**Re: Betos Boots  
5901 Rio Vista Dr. NW  
Request Permanent CO - Accepted  
Engineer's Stamp dated: 5-12-16 (L11D068)  
Certification dated: 11-21-16**

## DRAINAGE AND TRANSPORTATION INFORMATION SHEET (REV 1/2016)

Project Title: Betos Boots (Retail) Building Permit #: \_\_\_\_\_ Hydrology File #: L-11 2068  
DRB#: \_\_\_\_\_ EPC#: \_\_\_\_\_ Work Order#: \_\_\_\_\_  
Legal Description: Lot 1, Blk 6, Los Altos Subd.  
City Address: 5901 Rio Vista Dr SW

Clark Consulting Engineers 19 Ryan Road Edgewood, New Mexico 87015 Tele: (505) 281-2444 Cell: (505) 264-8042	
DATE	REVISION
6/15/16	ADD. TCL COM'TS.
7/8/16	ADD. (2) TCL
7/19/16	
DESIGNED BY: PWC CHECKED BY: PWC	
DRAWN BY: CCE DATE: 12/23/15	
JOB# BURK_RioVista FILE #: TCL	
1 OF 1

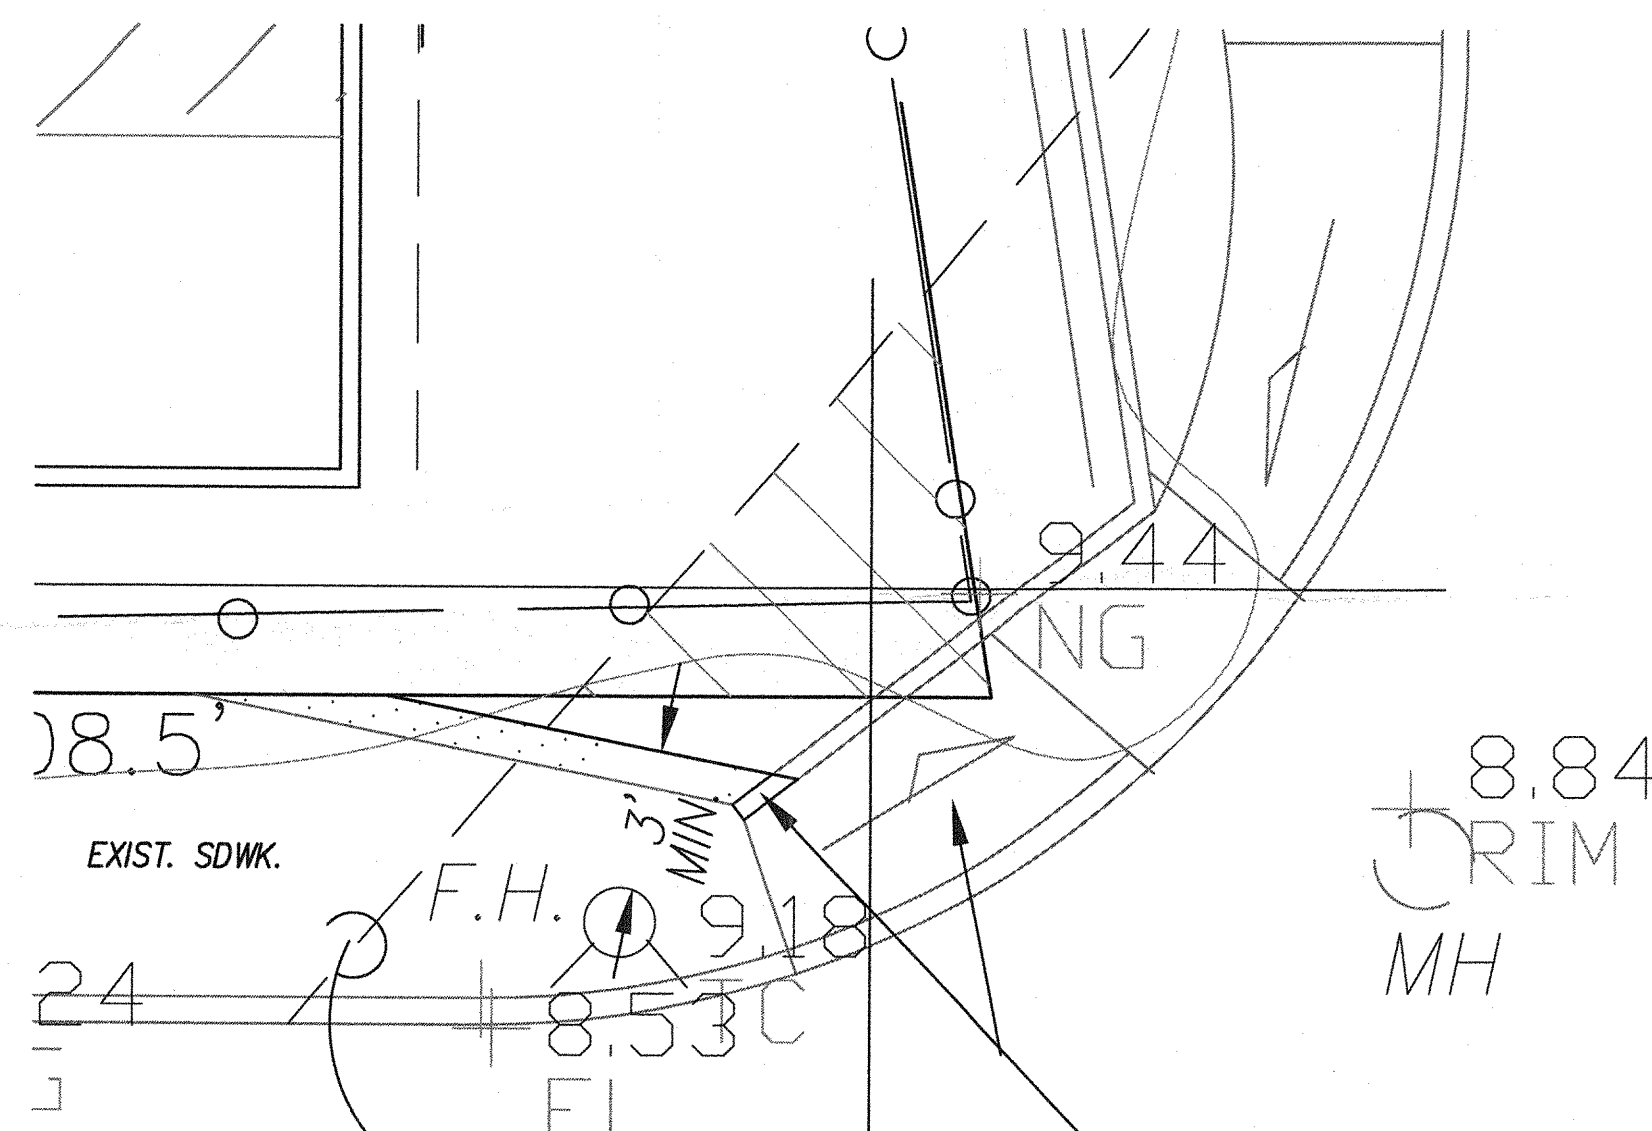
1. The ADA accessible parking sign must have the required language per 66-7-352.4C NMSA 1978 "**Violators Are Subject to a Fine and/or Towing.**" Please call out detail and location of HC signs.

2. The ADA access aisles shall have the words "**NO PARKING**" in capital letters, each of which shall be at least one foot high and at least two inches wide, placed at the rear of the parking space so as to be close to where an adjacent vehicle's rear tire would be placed. (66-1-4.1.B NMSA 1978)

3. The drive pad located at the southwest corner of the property will need to be closed and replaced with sidewalk, curb and gutter. As called out on the approved TCL.
